## The Thanet Extension Offshore Wind Farm Order

### Summary of Oral Submissions made at ISH2 submitted on behalf of the Port of London Authority and Estuary Services Limited

Unique Reference Number	11051.33 / 39014.1
Document Ref.	PLA2 / ESL2
Author	Winckworth Sherwood LLP
Date	7 January 2018

Vessel Traffic Survey - Passenger Tracks.

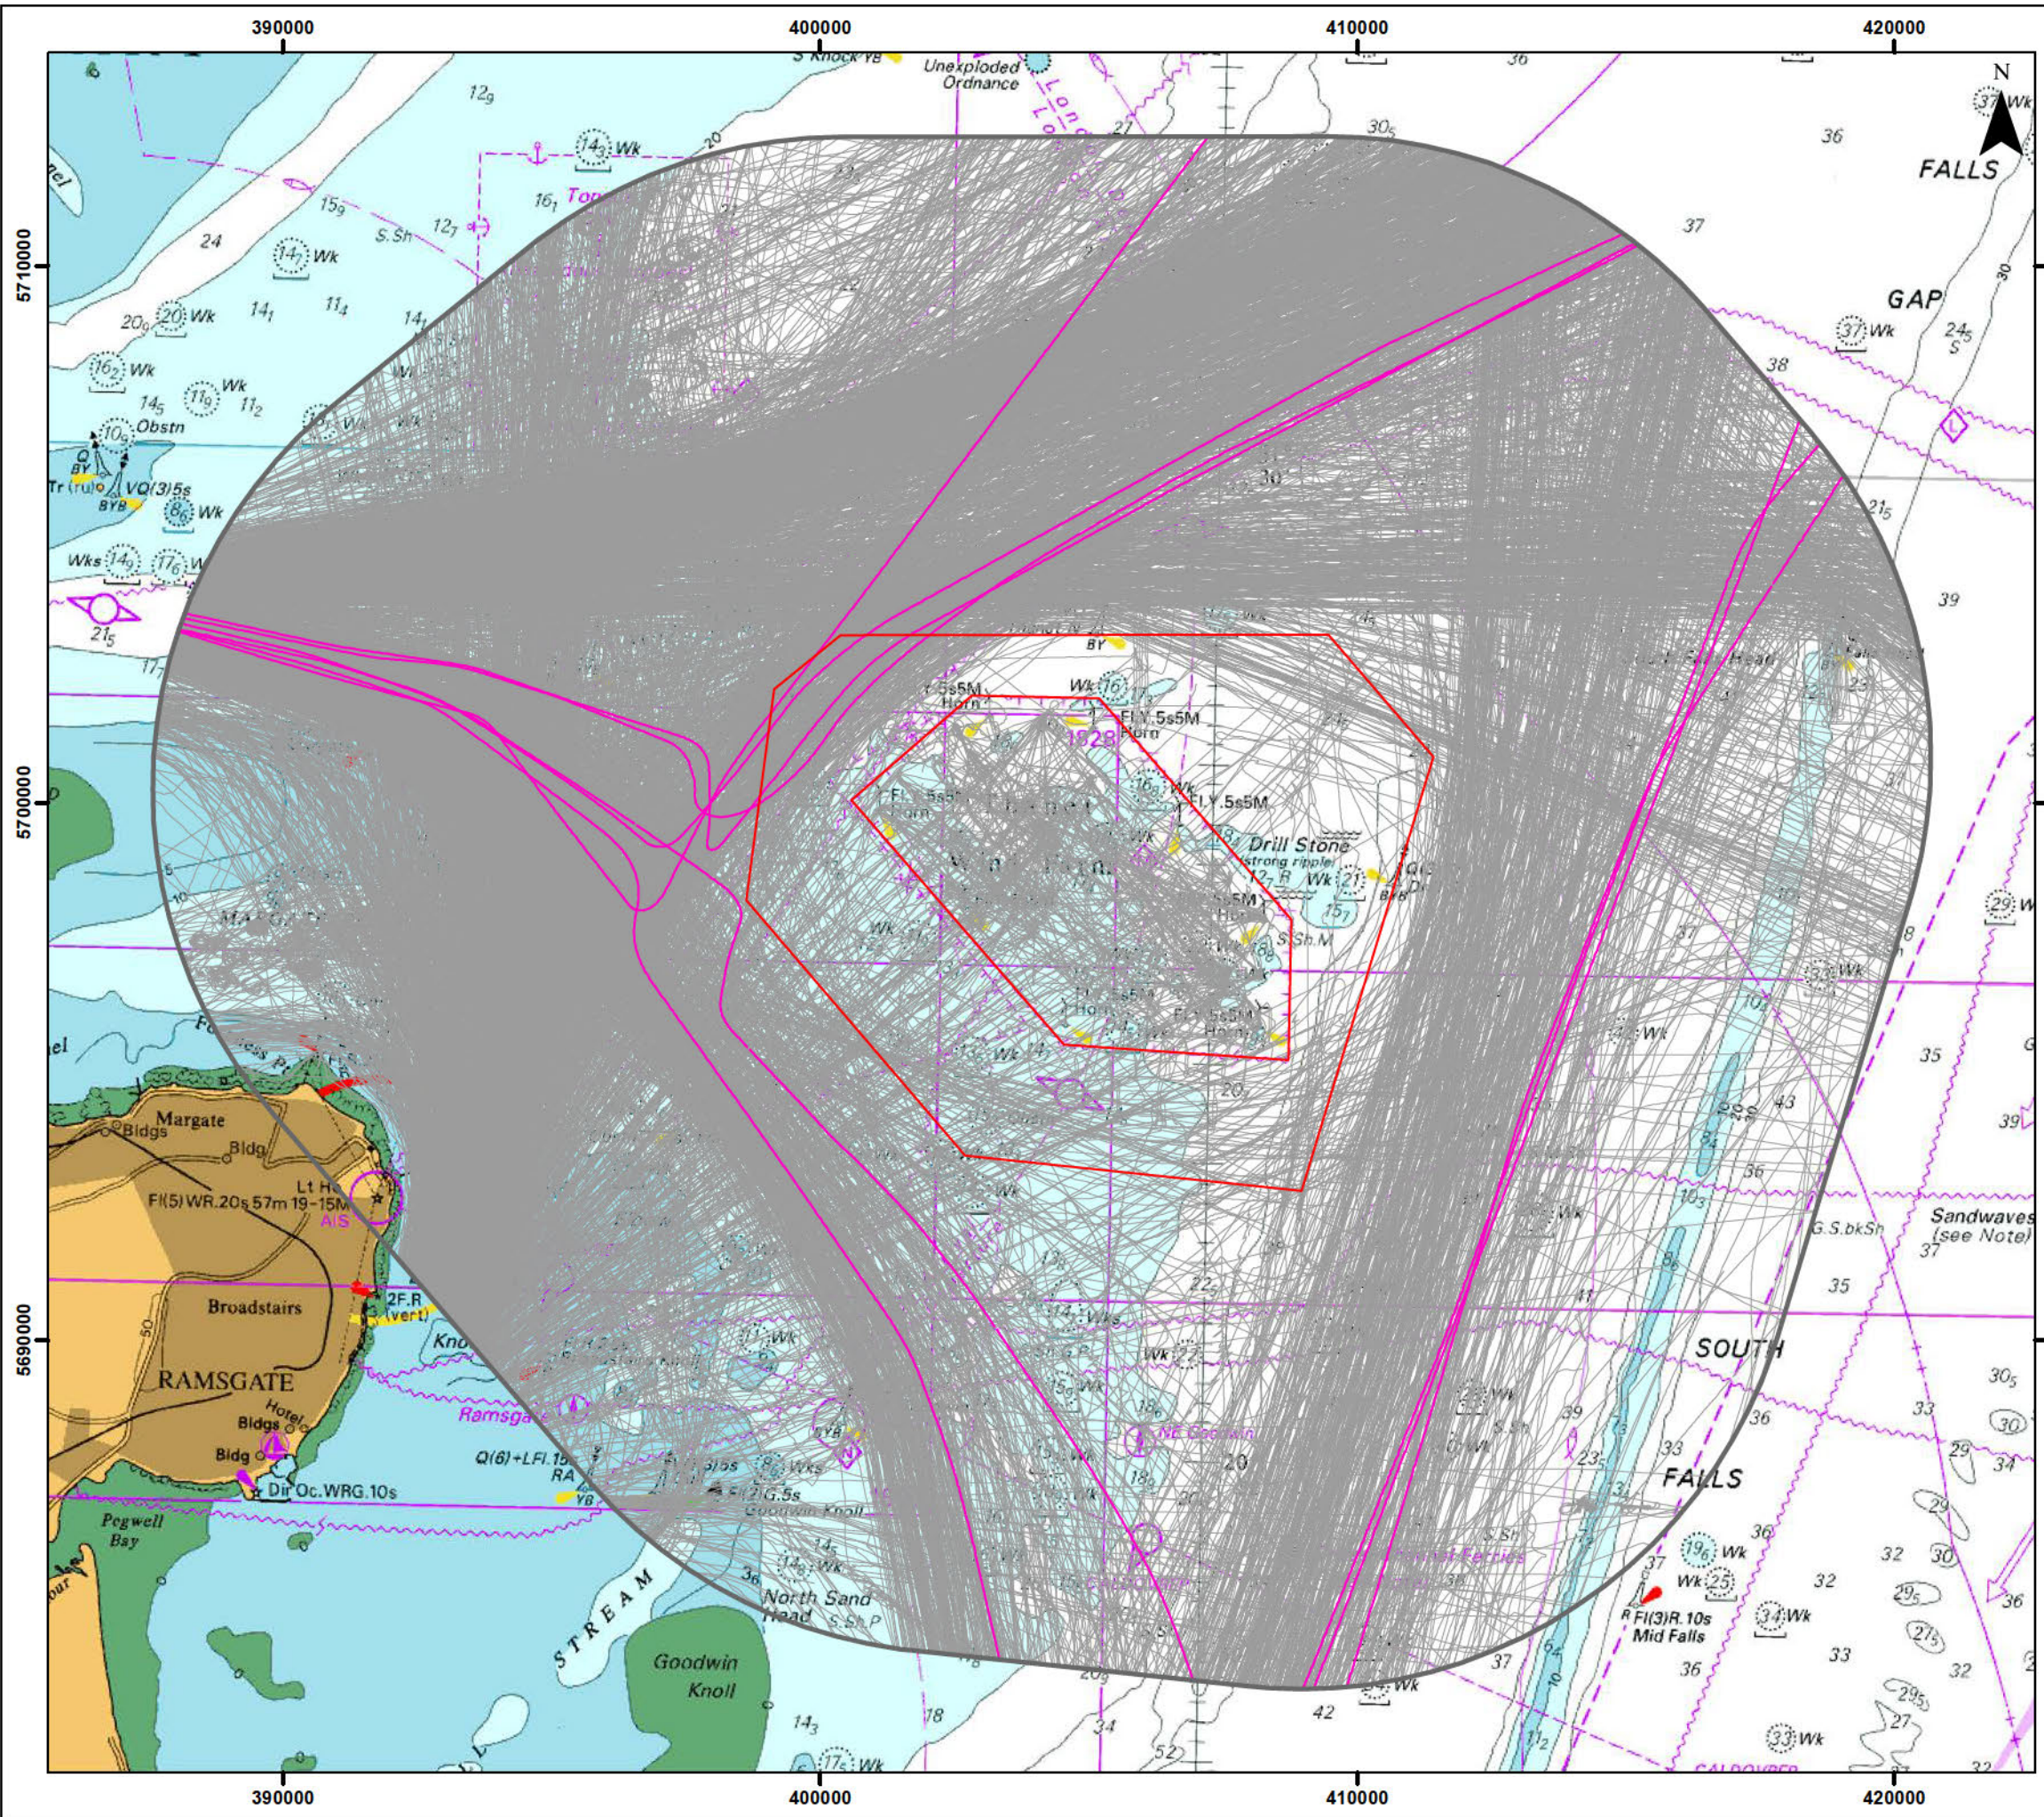
- 3.2 Mr Jackson went on to explore ESL's concerns about the data used in the NRA. The figures gathered in winter were taken in the lightest data window that could have been used. The site survey which references passenger vessels was over a two week early summer period which would not accurately reflect traffic in the area. Although the data splits out different types of traffic, it does not deal with interactions between vessels and therefore is not representative of the whole picture.

Vessel Traffic Survey - Recreational Tracks.

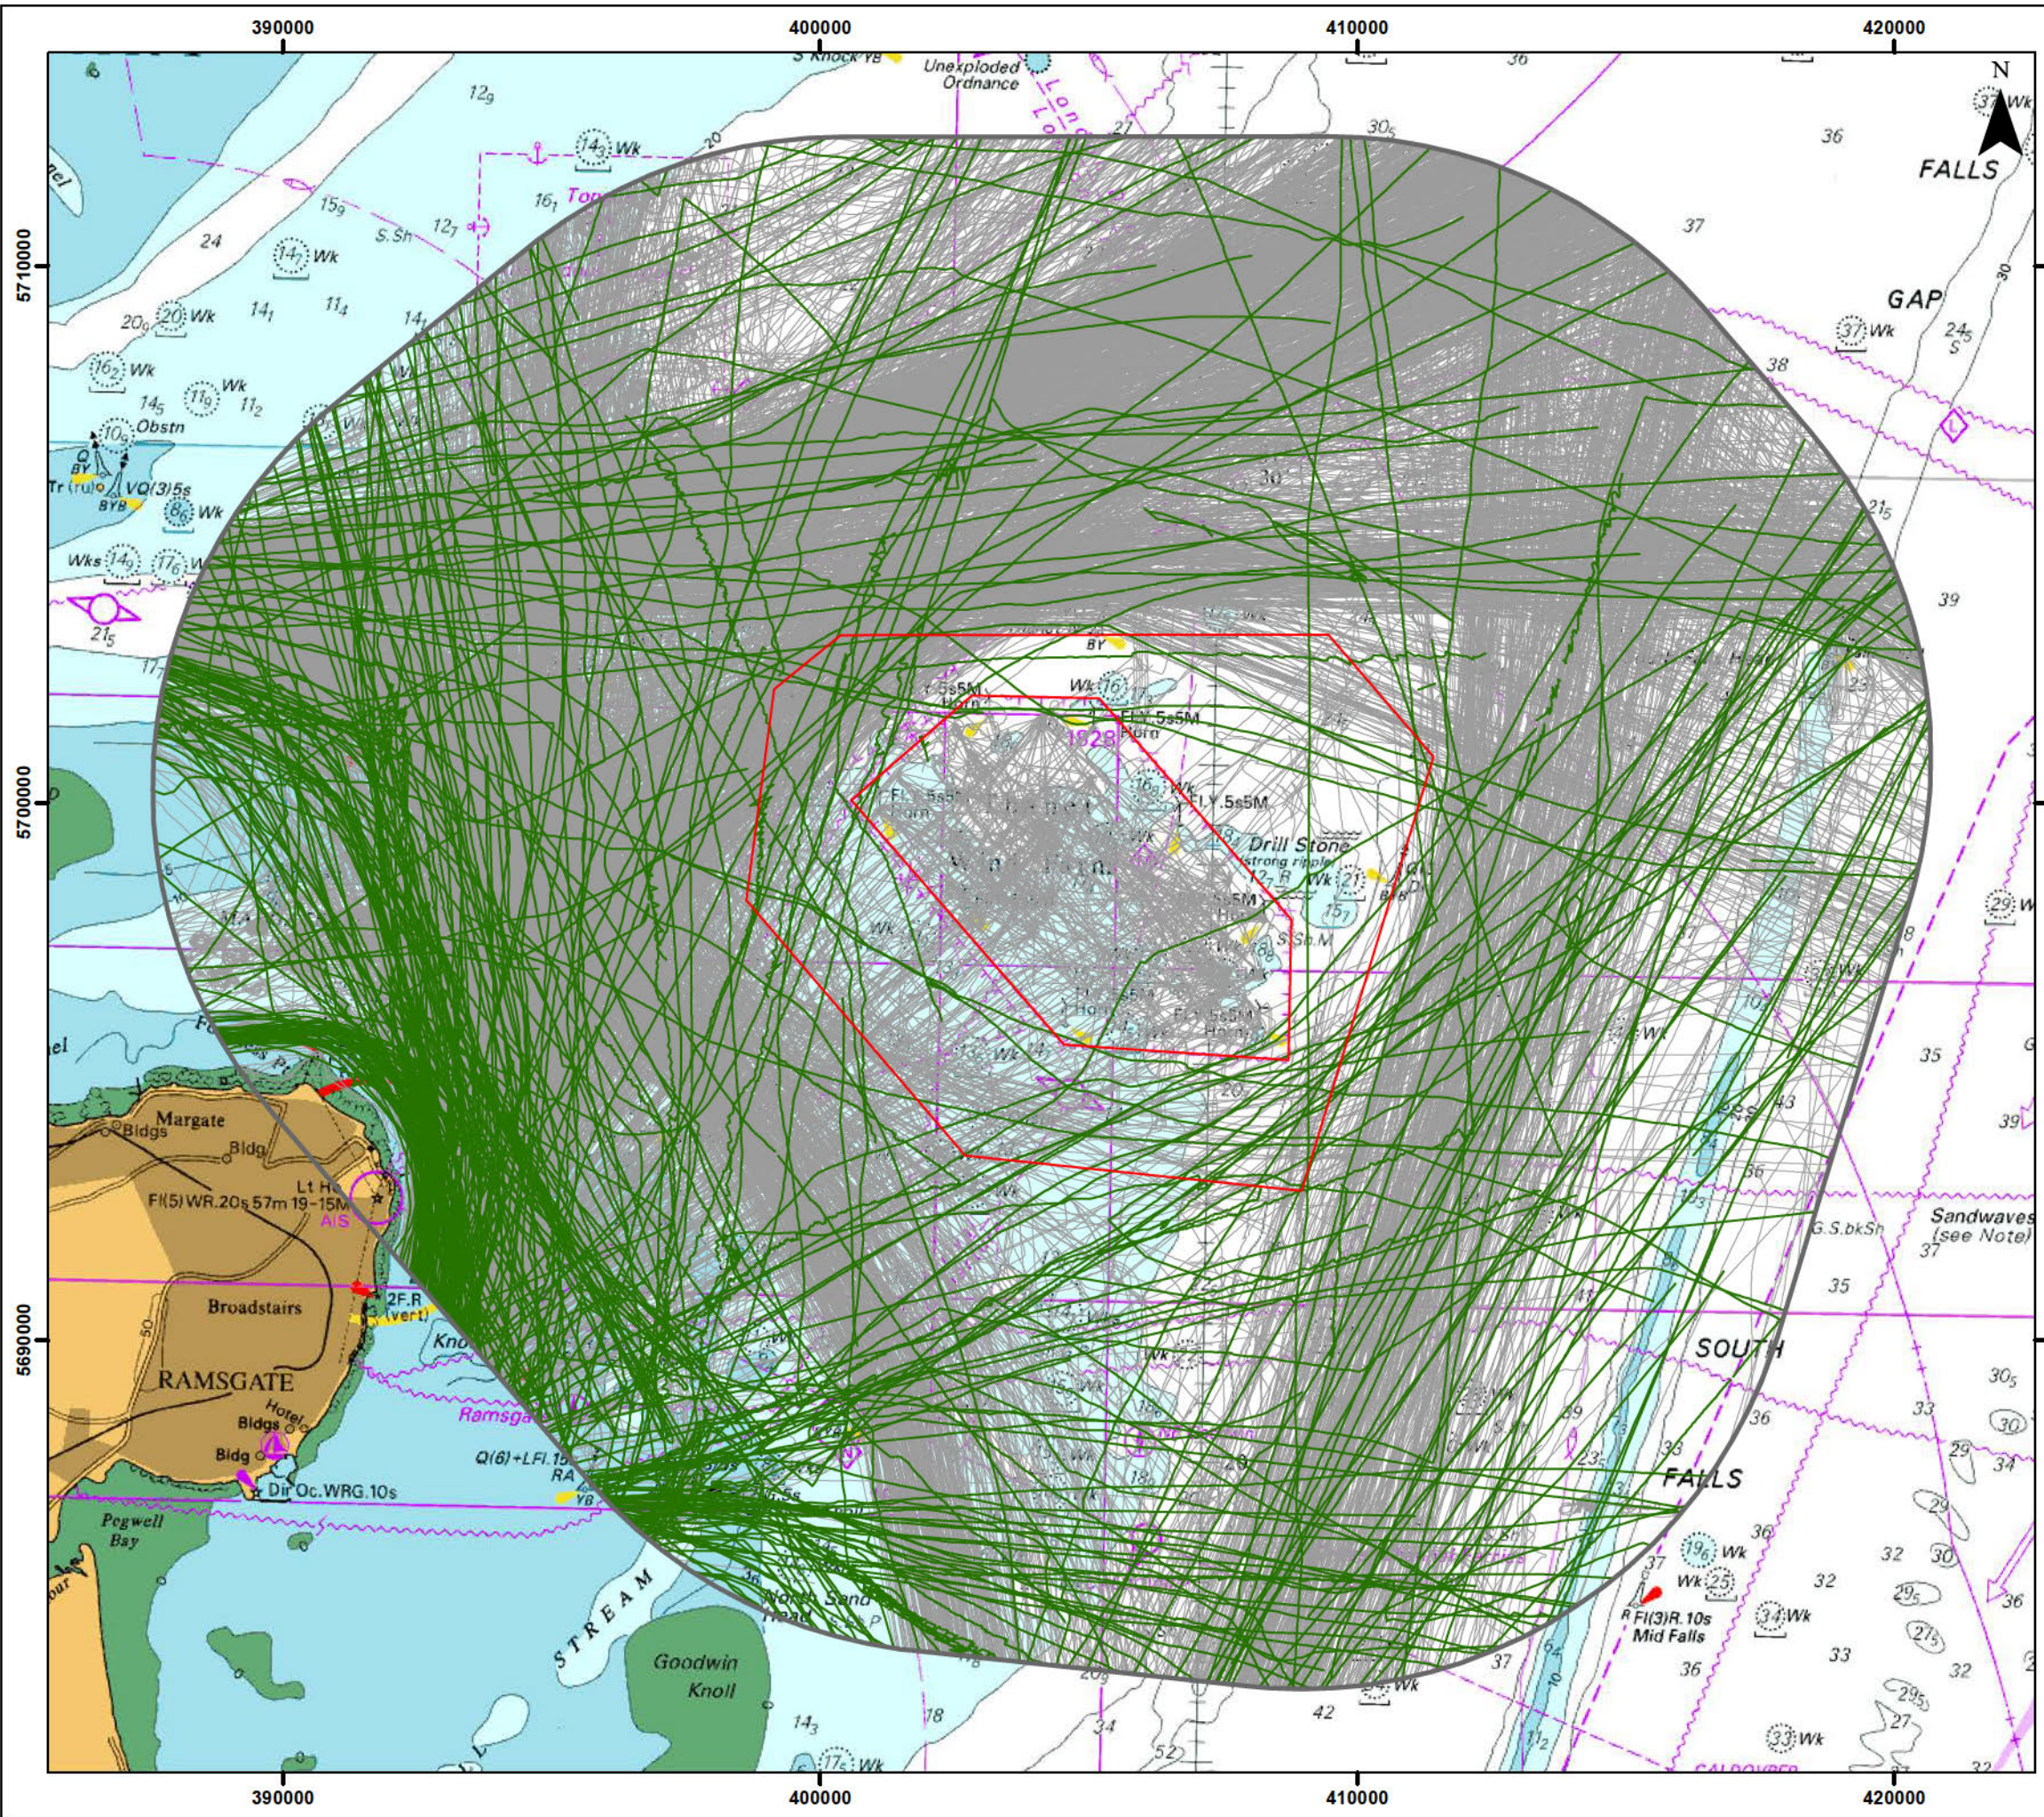
recreational vessels. The interaction between ships and leisure craft is not adequately reflected in the NRA, partially because leisure craft are not required to carry AIS, and because the traffic representations throughout the NRA are so dense in presentation that individual vessel interactions are very hard to recognise. Mr Jackson went on to say that whilst the NRA mentions the seasonal bias it does not go far enough to represent seasonal variations in leisure traffic. The impact of all small craft, commercial or otherwise is not fully represented in the NRA.
